Our Reference: P1427.002L

18 February 2014

**RE : TWEED ULTIMA WHARF STREET – RESPONSE TO COUNCIL AND STATE GOVERNMENT
INFORMATION REQUEST**

This letter provides further information with respect to traffic element requests for additional information from the New South Wales Department of Planning and Infrastructure dated 24th December, 2013 (DA 456-10-2013 MOD 6) and the Tweed Shire Council dated the 20th December, 2013 (DA04/0016.16 LN22600). Our response is outlined below:

Figure 15: Indented service bay along Navigation Lane.

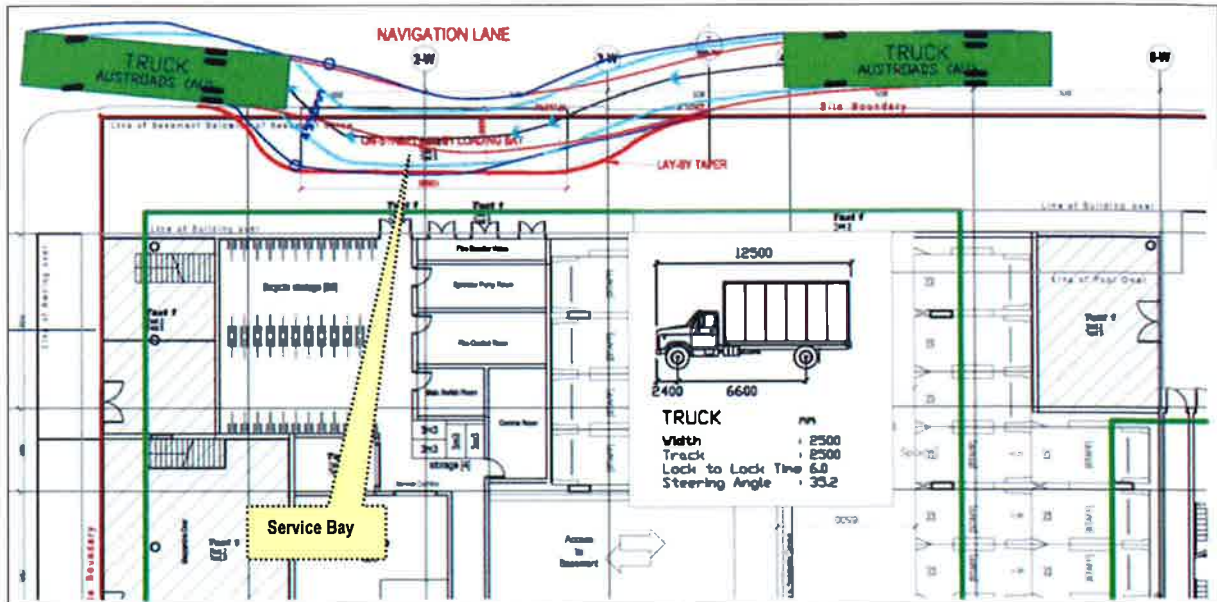
3.2 Service vehicle access

Service vehicle access to the Stage 2 building is proposed via a 'reverse in' arrangement off Navigation Lane. The Traffic Assessment notes that this arrangement is as per the original consent and is not expected to cause significant problems due to the service lane's "low traffic volumes and low speed environment" (p.11). Whilst it is noted that existing consent exists for the reverse in arrangement, it is likely that such a scheme would only be acceptable on the basis that Navigation Lane experiences very low traffic volumes. Given that the proposal will result in up to 78 additional vehicle movements per hour along the Navigation Lane, the proposed modification increases the likelihood of dangerous situations involving service vehicles blocking traffic attempting to egress the site. Such situations could be problematic as it would require blocked vehicles to reverse several hundred metres along Navigation Lane. This approach is undesirable as it would create dangerous situations for both motor vehicles and pedestrians. Given the existing arrangement for service vehicles to access Navigation Lane, reconsideration should be given to the current practicality of the basement level 1 connection to the Western constructed towers.

- It is noted service vehicle access is from Navigation Lane. This access requires reversing from Navigation Lane into the service access bay. All service vehicle arrangements should be able to drive forward into the access bay and exit the site in a forward direction. The application states that this type of arrangement was approved in the original development by the Department of Planning and is proposed in the amended development due to the 'constrained nature' of the laneway. This type of arrangement for a service bay is not generally supported. It is noted that this arrangement has been previously approved for the original development.

To accommodate service vehicle access to the site in a forward gear an "on-street" service bay has been included into the revised design. This loading facility maintains pedestrian footpath width. In addition, the "on-street" configuration allows use of the loading bay by surrounding sites and removes the need for loading facilities to be installed on Bay Street. The proposed indented service bay is proposed on Navigation Lane fronting the Stage 2 building and allows servicing access without impacting Navigation Lane traffic. The design of the service bay includes the following:

- 12.5 metre length at full width to allow standing access for a refuse collection vehicle;
- transition tapers for efficient forward ingress and egress bay access via Navigation Lane; and
- a 3 metre bay width to store a service vehicle clear of Navigation Lane through traffic.

The proposed indented service bay is considered an appropriate option for the site's servicing access requirements. The bay eliminates the need to reverse in a constrained area and results in an efficient use of space.

The development plans have been amended to accommodate service vehicle access to the site in a forward gear. The access is via a indented on-street service bay located on Navigation Lane. The design of the servicing bay includes the following:

- 12.5 metre length at full width to allow standing access for a refuse collection vehicle;
- transition tapers for efficient forward ingress and egress bay access via Navigation Lane; and
- a 3 metre bay width to store a service vehicle clear of Navigation Lane through traffic.
